KITITAS COUNTY

MEMORANDUM

TO: All Staff
FROM: Public Works Plan Review Team
DATE: June 1, 2026
SUBJECT: AU-26-00007 Hill

SITE PLAN  
 SCALE 1" = 50'-0"  
 0' 50' 100' 150'

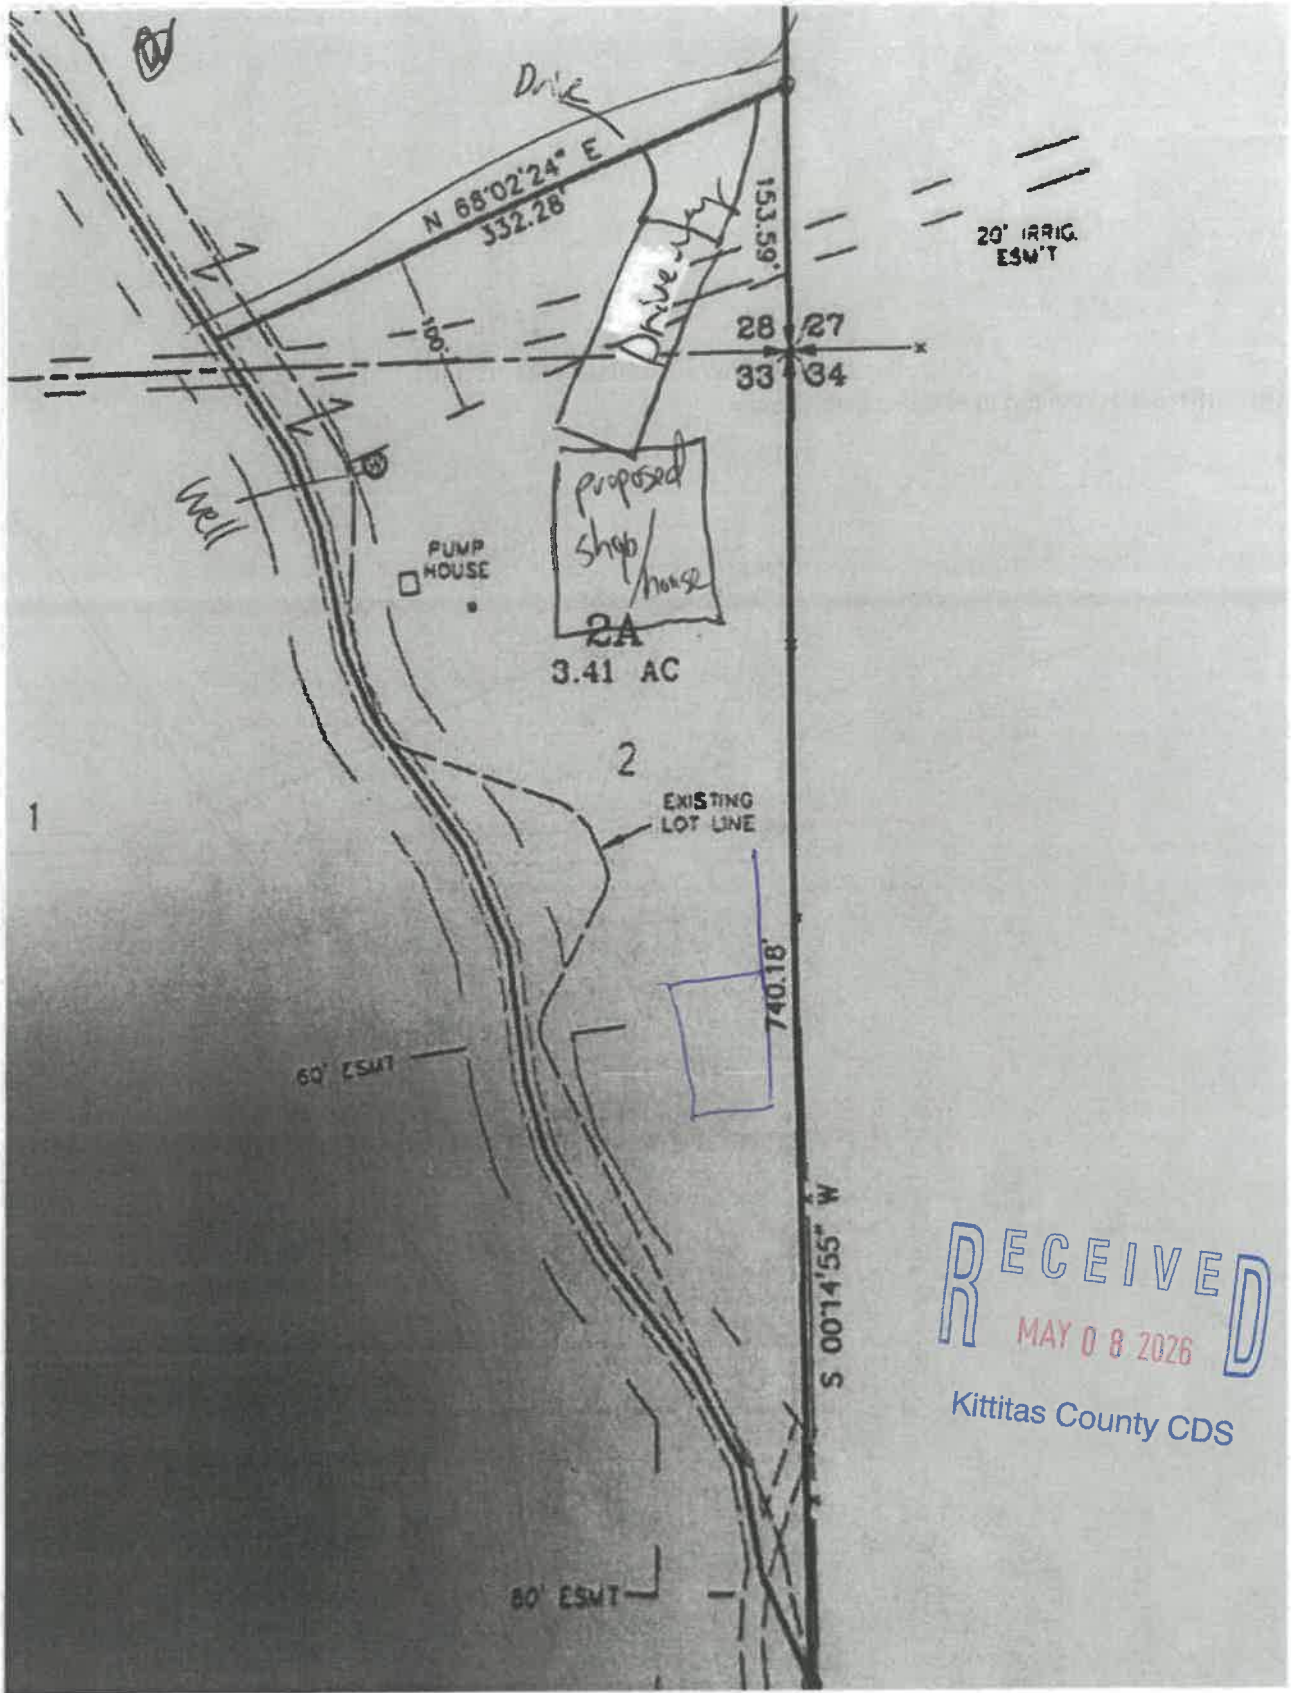
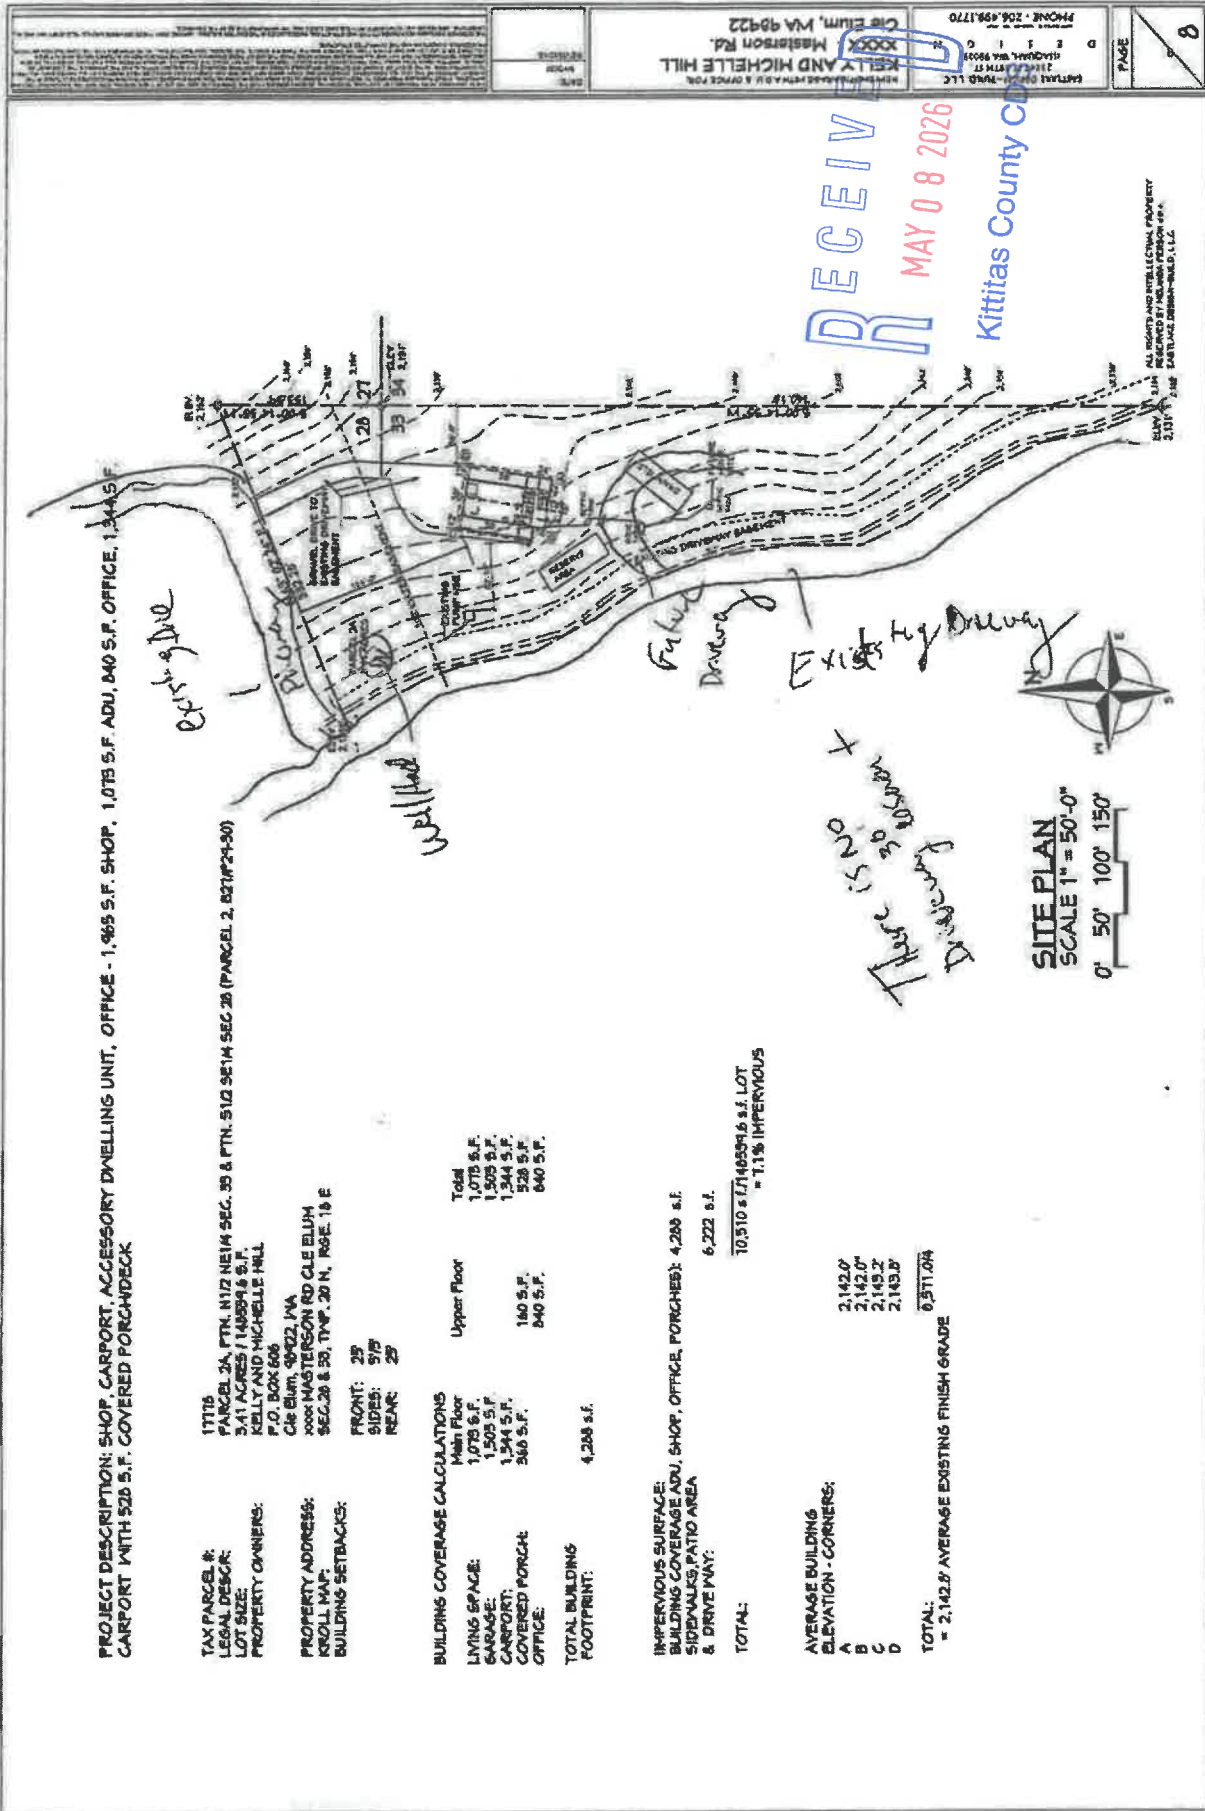
SURVEY	<p>CDS considers the nearest lot line to the proposed ADU as a rear yard. Due to the proposed building being on this setback line, the building envelope should be staked out by a surveyor licensed in the State of Washington to prevent the possibility of encroaching into the setback area. (JT)</p>
TRANSPORTATION CONCURRENCY	<p>Not applicable to this project as proposed. (RC)</p>
FLOOD	<p>Parcel #17778 is not mapped within a FEMA identified special flood hazard area (1% annual chance flood zone). A floodplain development permit is not required for the proposed ADU. (SC)</p>
WATER MITIGATION/ METERING	<p>The proposed ADU requires water mitigation and metering per KCC 13.35.027 since it is a new use of groundwater. Public Works has issued a water mitigation certificate for the project, WM-26-00027. The water meter must be installed and inspected prior to building final. (SC)</p>
